Our Ref: DOC19/935384  
Your Ref: SSD-7293

**Sancrox Quarry Expansion Project (SSD-7293)**

Enclosure: Attachment 1 detailed BCD Comments – Sancrox Quarry Expansion Project (SSD 7293)

## Attachment 1: Detailed BCD Comments – Sancrox Quarry Expansion Project (SSD-7293)

Photograph 10

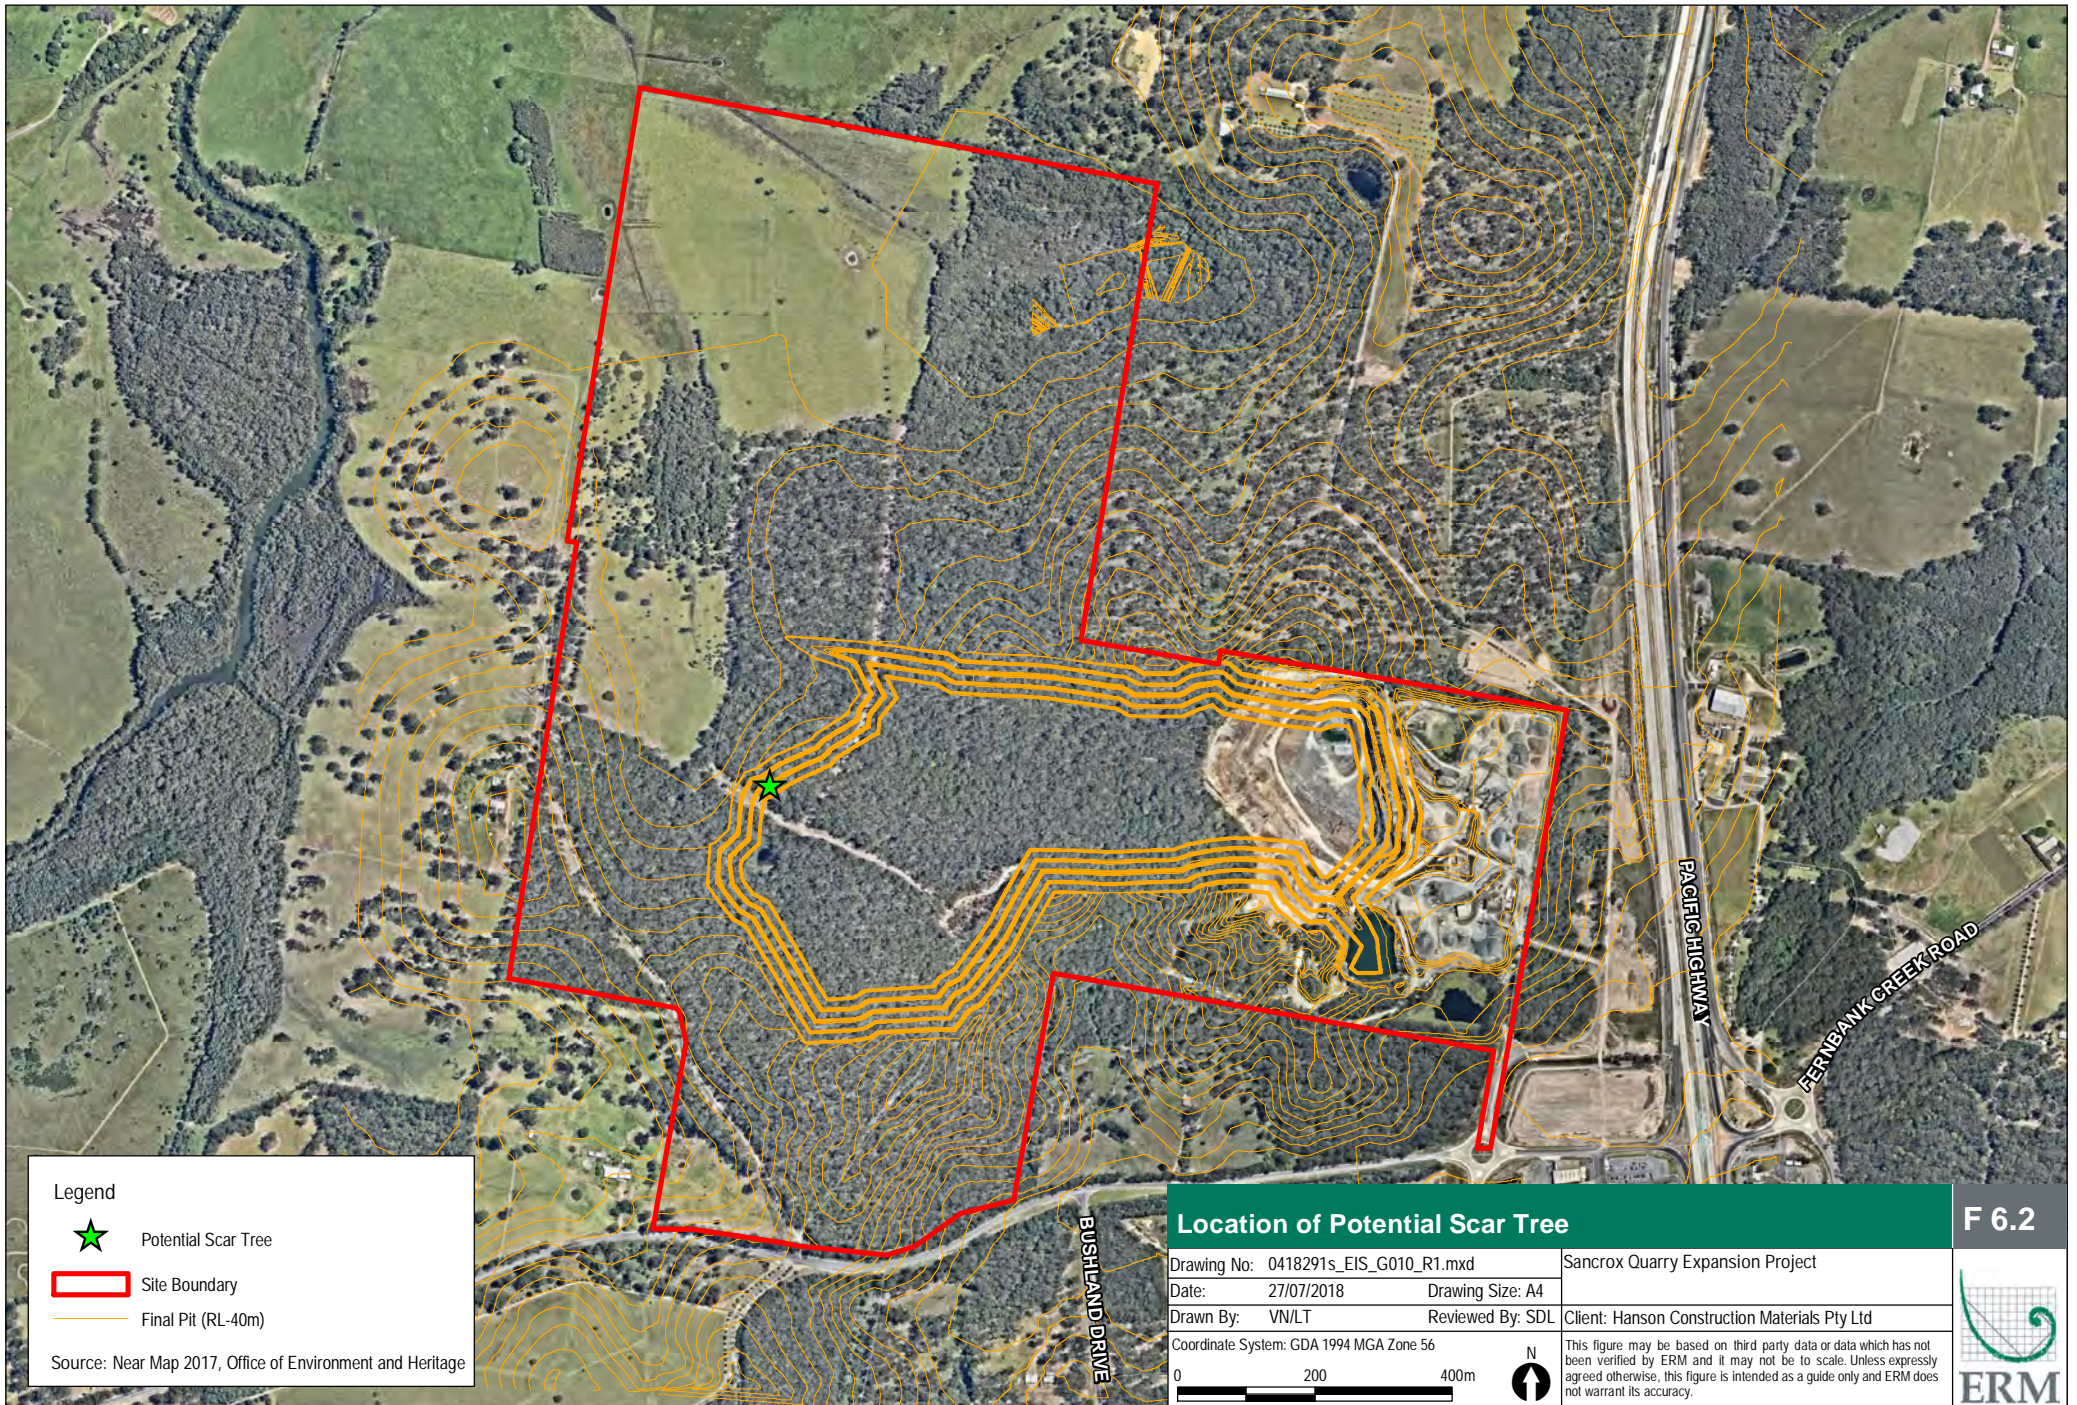
We also note that a possible Aboriginal scar tree was recorded in the field and that the report indicates that it is on the very edge of the proposed footprint for the quarry expansion yet no evidence of any attempt to modify the footprint to conserve the tree is provided in the EIS. Given that the tree is situated on the extreme perimeter of the proposed expansion we recommend that the footprint of the proposed expansion is amended to preserve the tree *in-situ*.

*The development footprint should be amended to preserve the Aboriginal scar tree.*

FBA Connectivity Maps

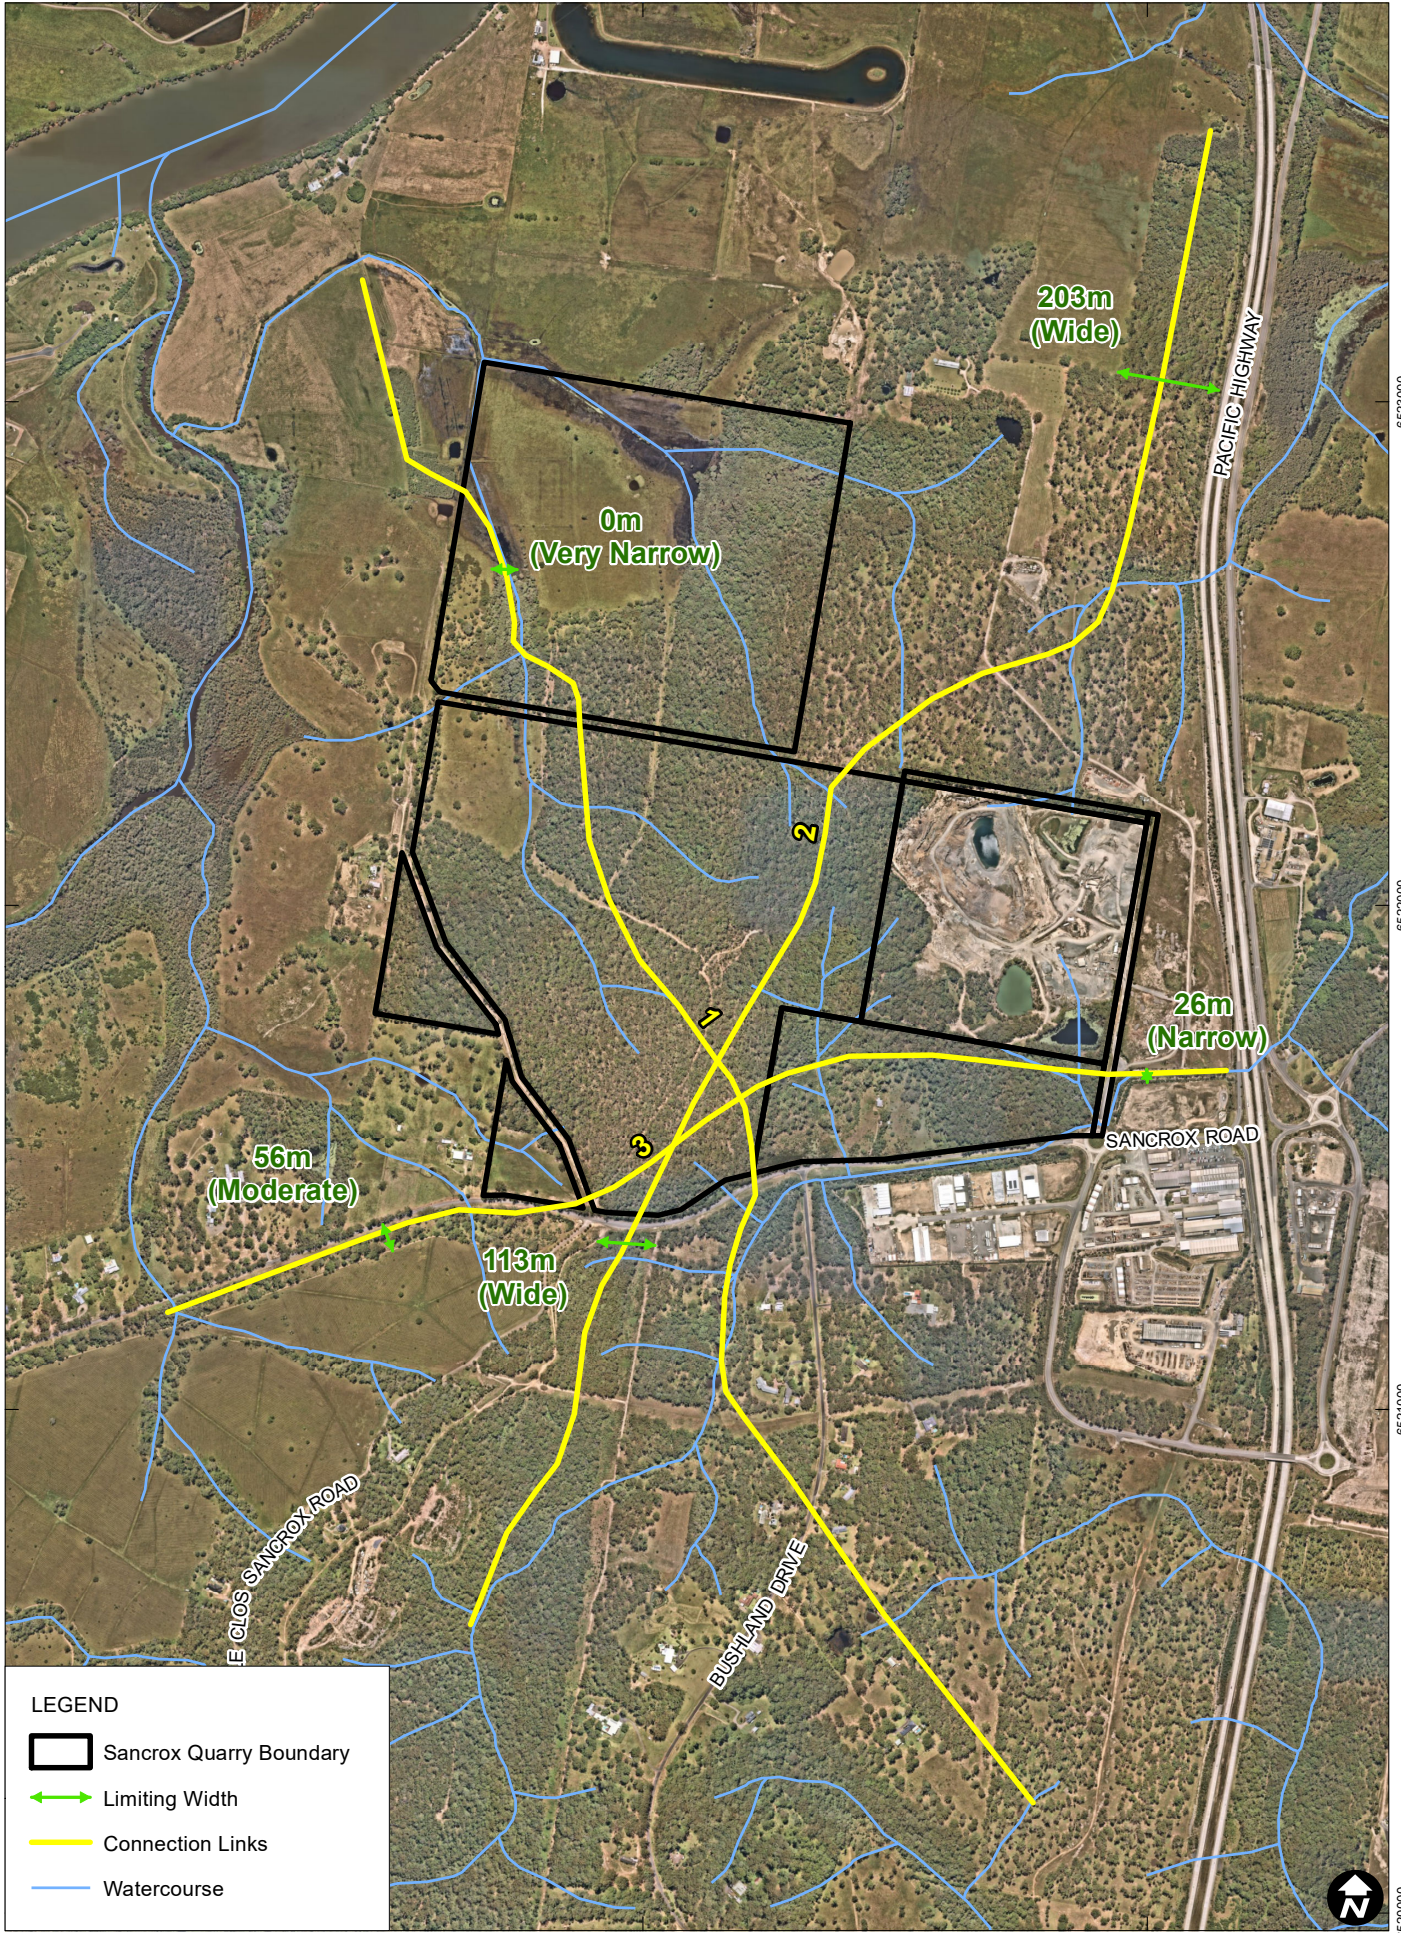
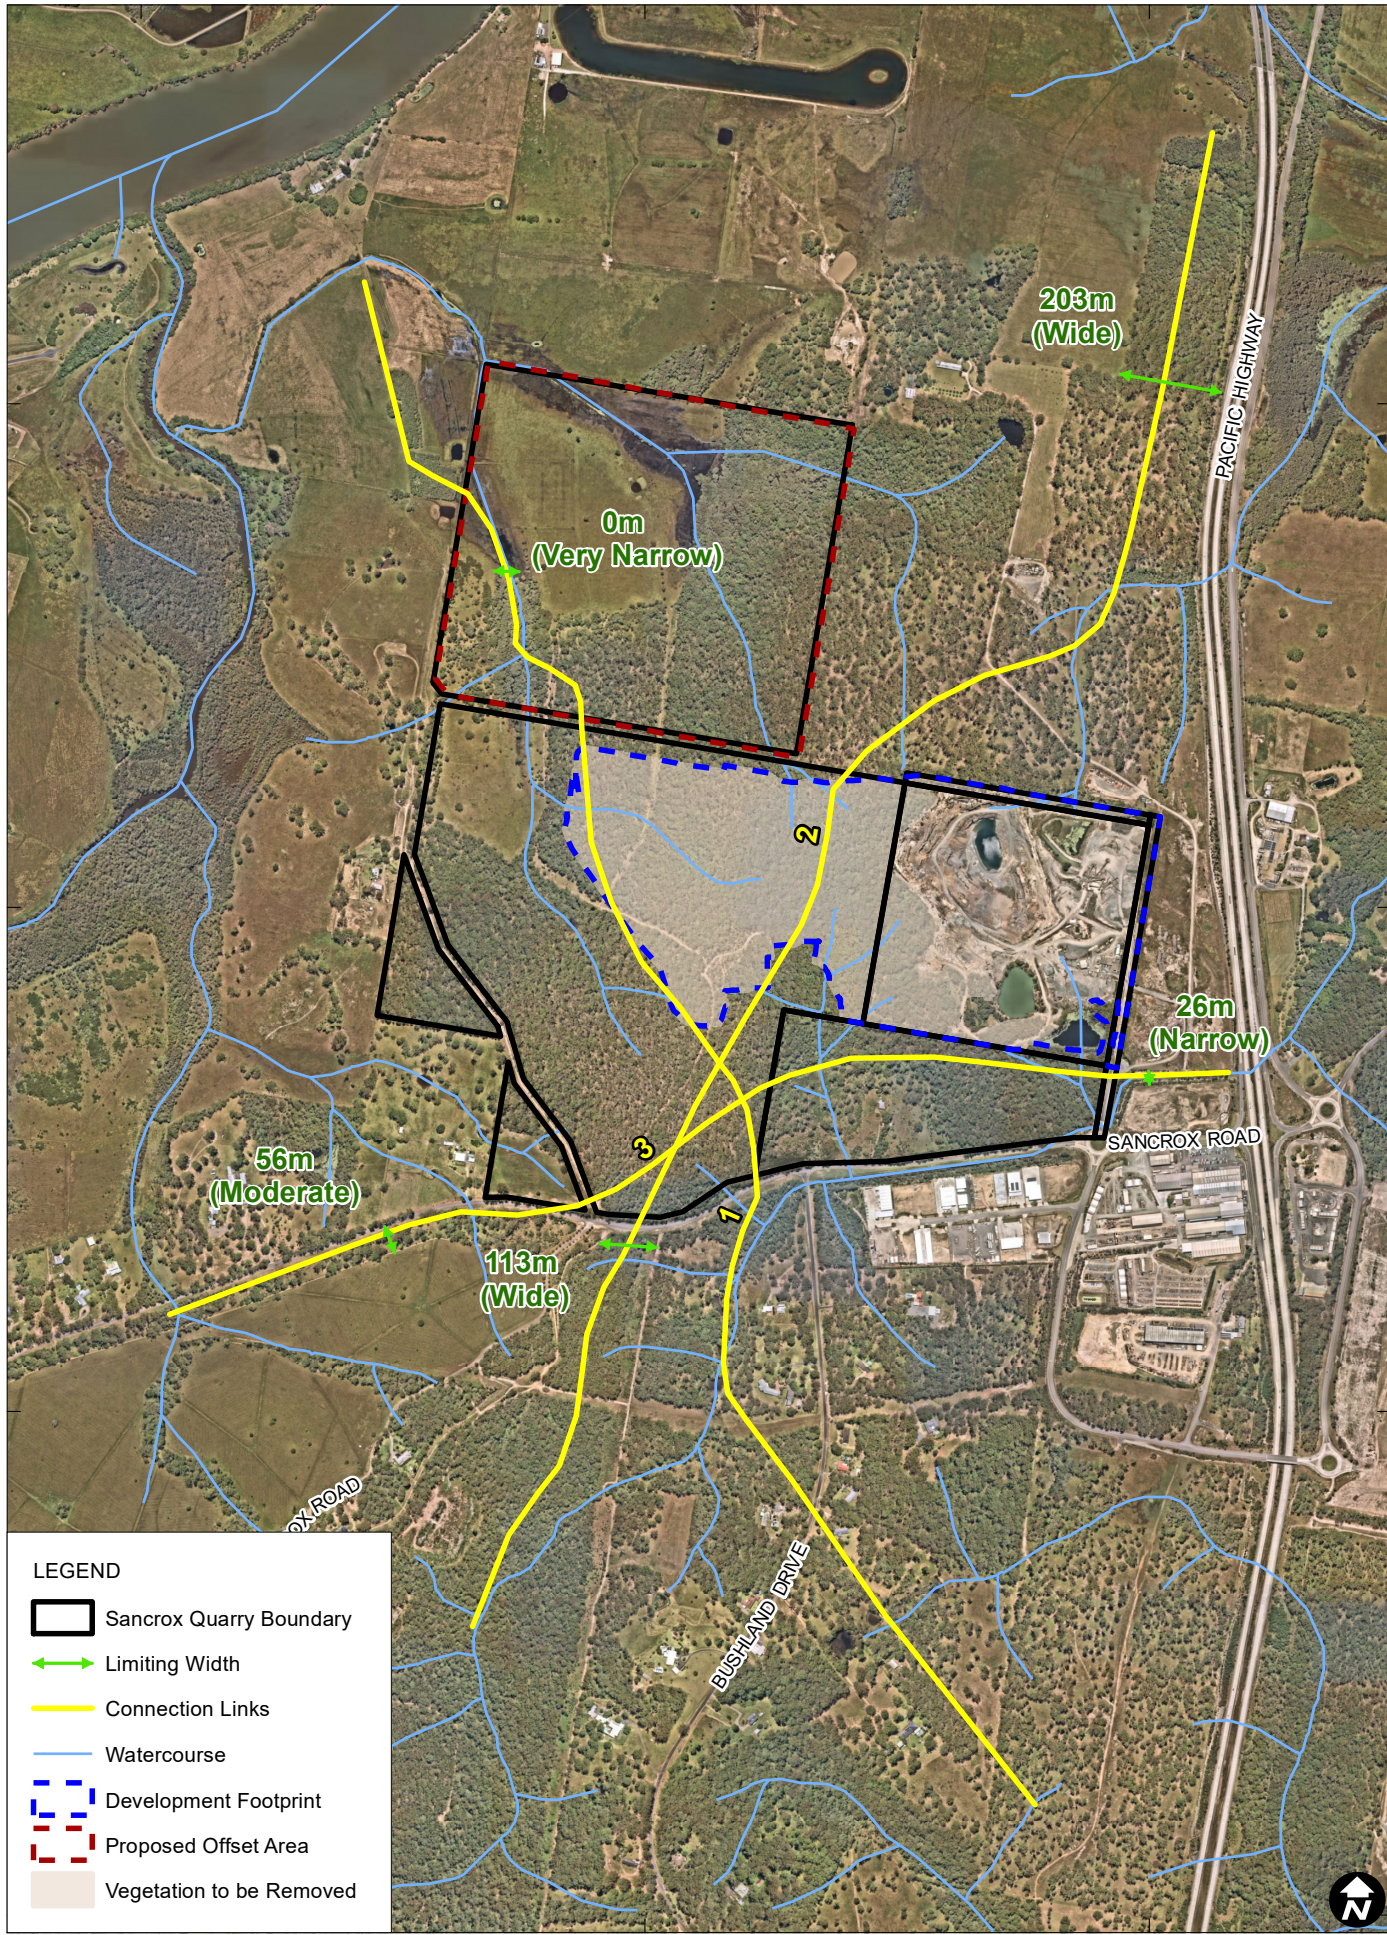
Appendix E to the BAR provides the maps of the connectivity assessment prepared as required by Appendix 4 of the FBA. The north-south connectivity links appear to be significantly affected by the proposed development, however section 2.9.2 of the BAR concludes that there will be no loss of connectivity.

*The BAR should provide further justification for the connectivity impacts associated with the proposed development.*
